THE SOD GUY - SALES LOT

SITE DEVELOPMENT PLANS

LOT 1, APPALOOSA HIGHWAY 24 SUBDIVISION FILING NO 1A

SALES OFFICE
GRADING AND EROSION CONTROL PLAN

SHEET NO:
C-04
DATE:
01/11/18
PAGE NO:
5 OF 6

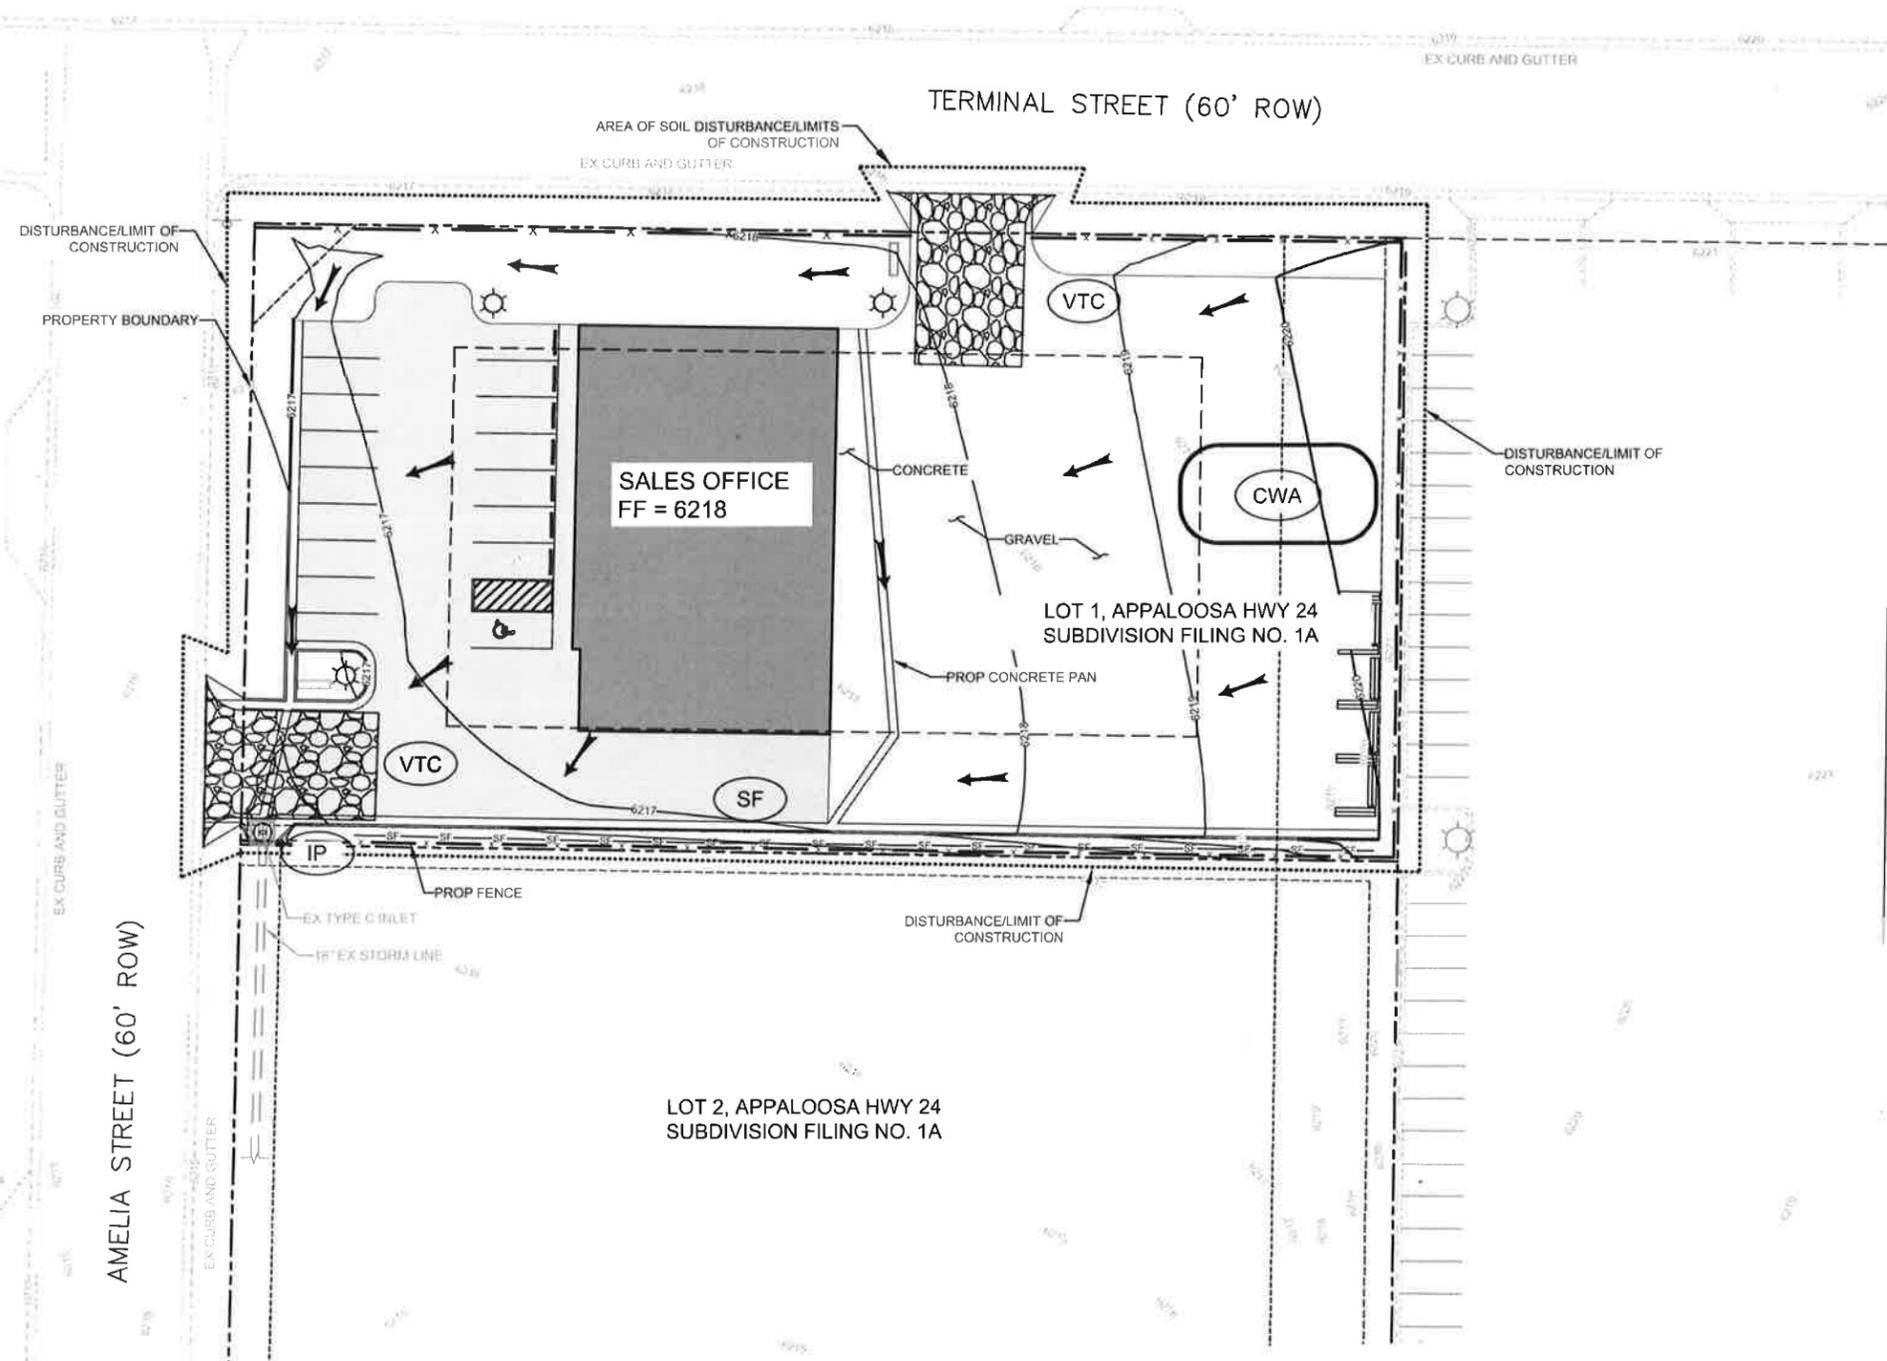
Label adjacent subdivision name and property parcel numbers.

Label adjacent subdivision name and property parcel numbers.

Show the construction staging area.
